# Work Change Proposal Request

Oak Street Lofts  
72 Oak Street  
Portland, ME 04101

PROPOSED REQUEST NUMBER: 1

ARCHITECT'S PROJECT NUMBER: 07.446

SKM-3

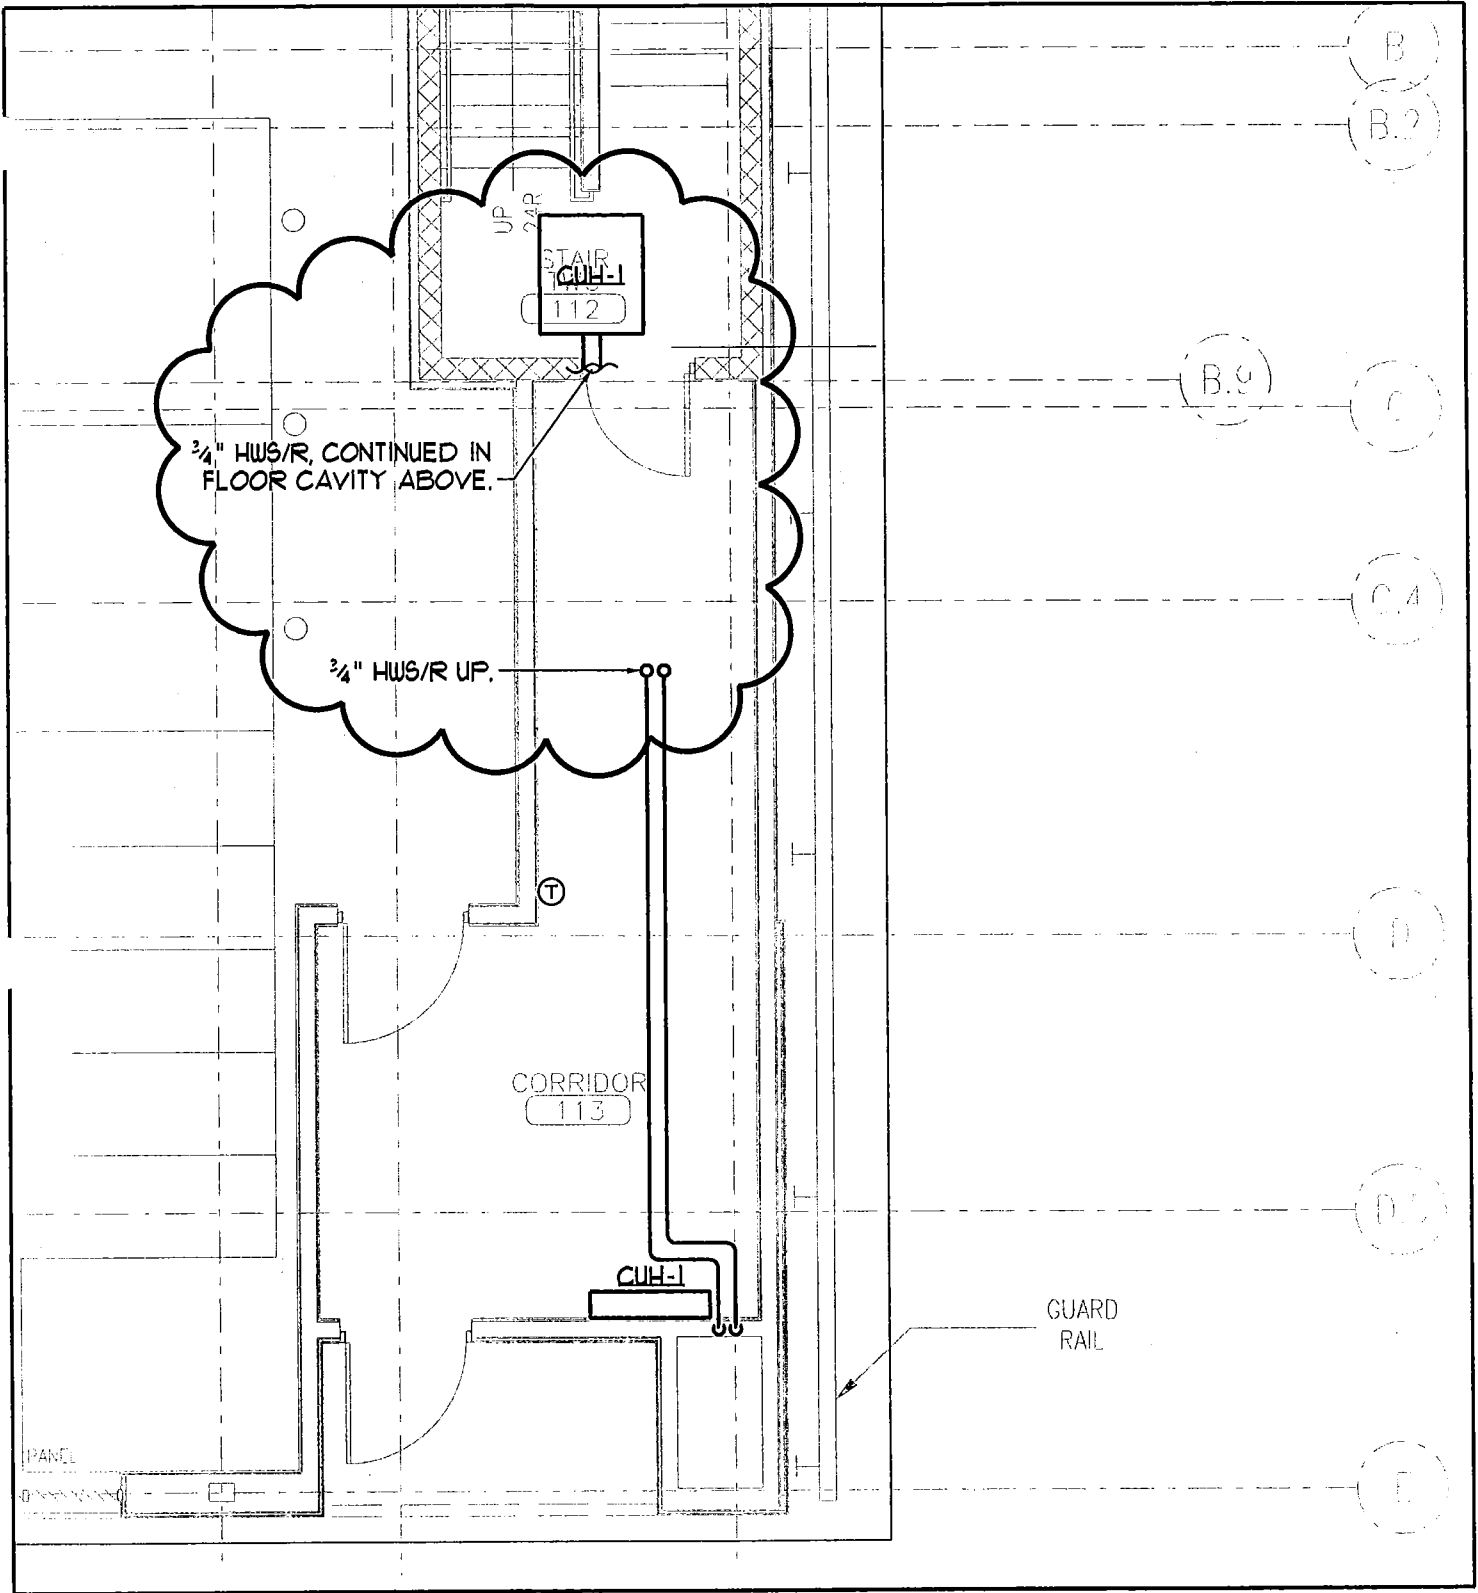
Provide and install all components of a work counter with sink on base cabinet as per the attached SKA-3, SKE-2 and SKM-3.

SKM-4

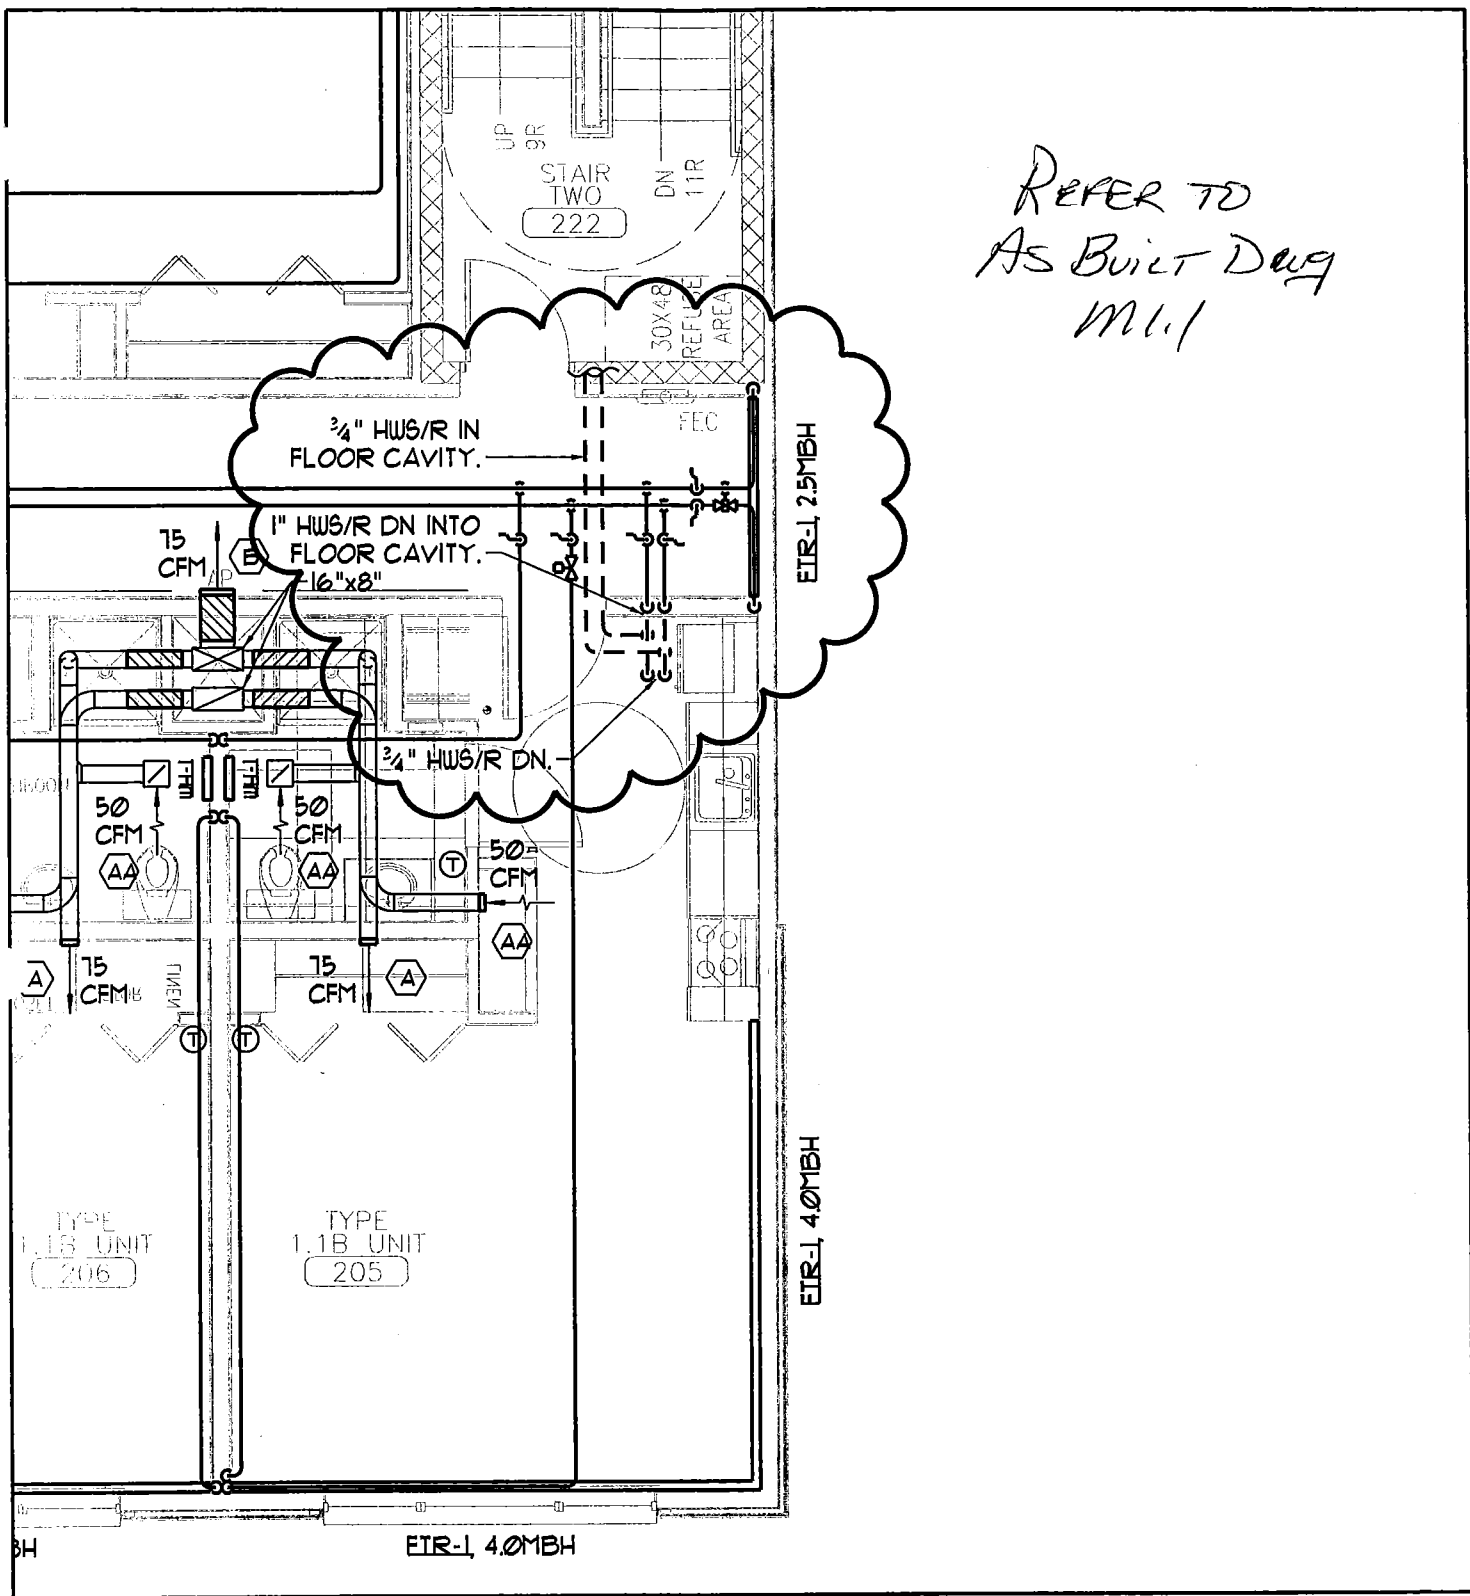
Provide and install Sterling ceiling mounted cabinet unit heater Model C1140-03 (2GPM) at Stair Two First floor ceiling in lieu of the specified wall mounted unit. Modify supply piping as indicated by the attached SKM-4 and SKM-5.
